WEST SUSSEX COUNTY COUNCIL CONSULTATION

TO:	Arun District Council FAO: Michael Eastham
FROM:	Highways, WSCC
DATE:	28/06/2018
LOCATION:	Quiet Waters, Roundstone Lane, Angmering, BN16 4AX
SUBJECT:	A/82/18/DOC Approval of details reserved by condition imposed under A/132/17/OUT relating to conditions 5-details of materials & finishes of buildings, surfaces for roads/footpaths, means of enclosure & parking of vehicles, 6-surface water drainage, 7-SuDS details, 10-landscape & layout, 11-refuse & recycling bins, 12-car, motorcycle & cycle parking, 13-location of fire hydrants, 14- decentralised & renewable or low carbon energy source, 16-covered & secured cycle parking & 27-noise levels
DATE OF SITE VISIT:	
RECOMMENDATION:	☐ Advice ☐ Objection ☐ Modification ☒ No Objection ☐ More Information ☐ Refusal
S106 CONTRIBUTION TOTAL:	N/A

Application A/82/18/DOC seeks the approval of conditions associated with planning permission A/132/17/OUT for 30 dwellings. The conditions relevant to the Highway Authority are as follows:

Drawing Title:
Proposed Materials Layout

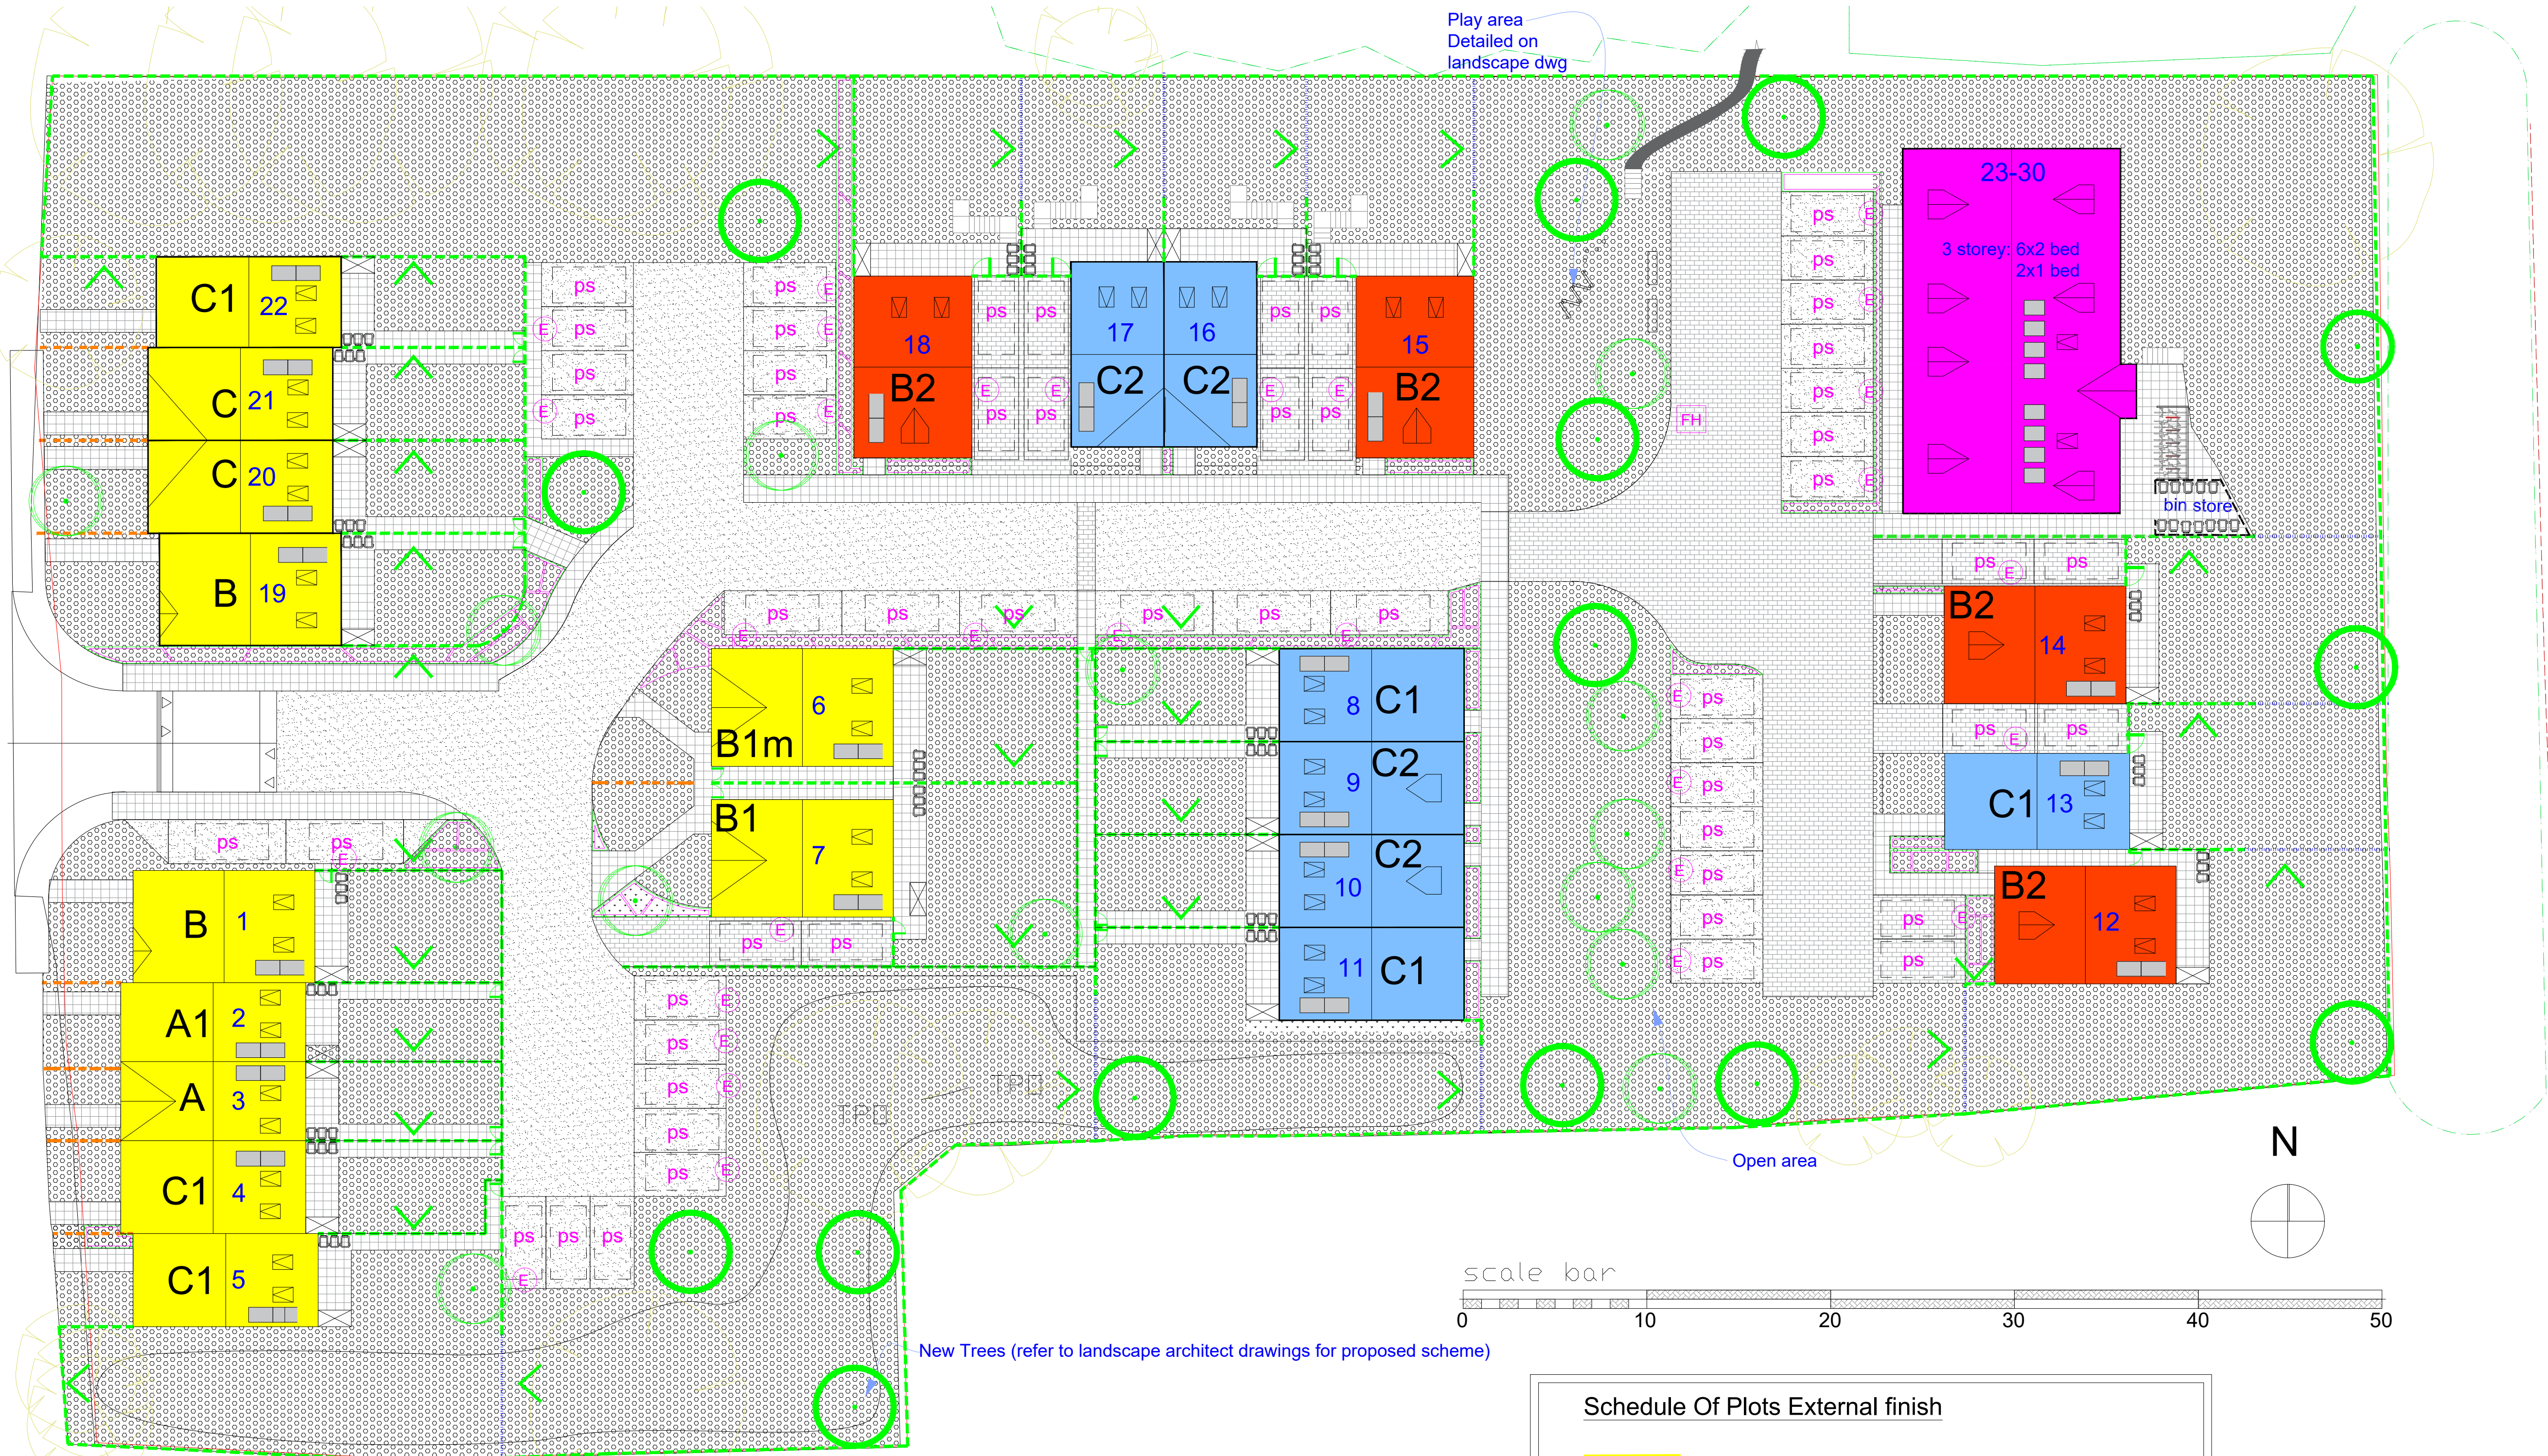
Condition 5 requires submission of details of materials for the roads and footpaths within the development. It is assumed that the road is to remain in private ownership and therefore any comments the Highway Authority would make in relation to the materials to be used are purely advice. The applicant is proposing block paving for the site access road and the Highway Authority have no objections to the approval of this condition on the basis that the road is to remain private.
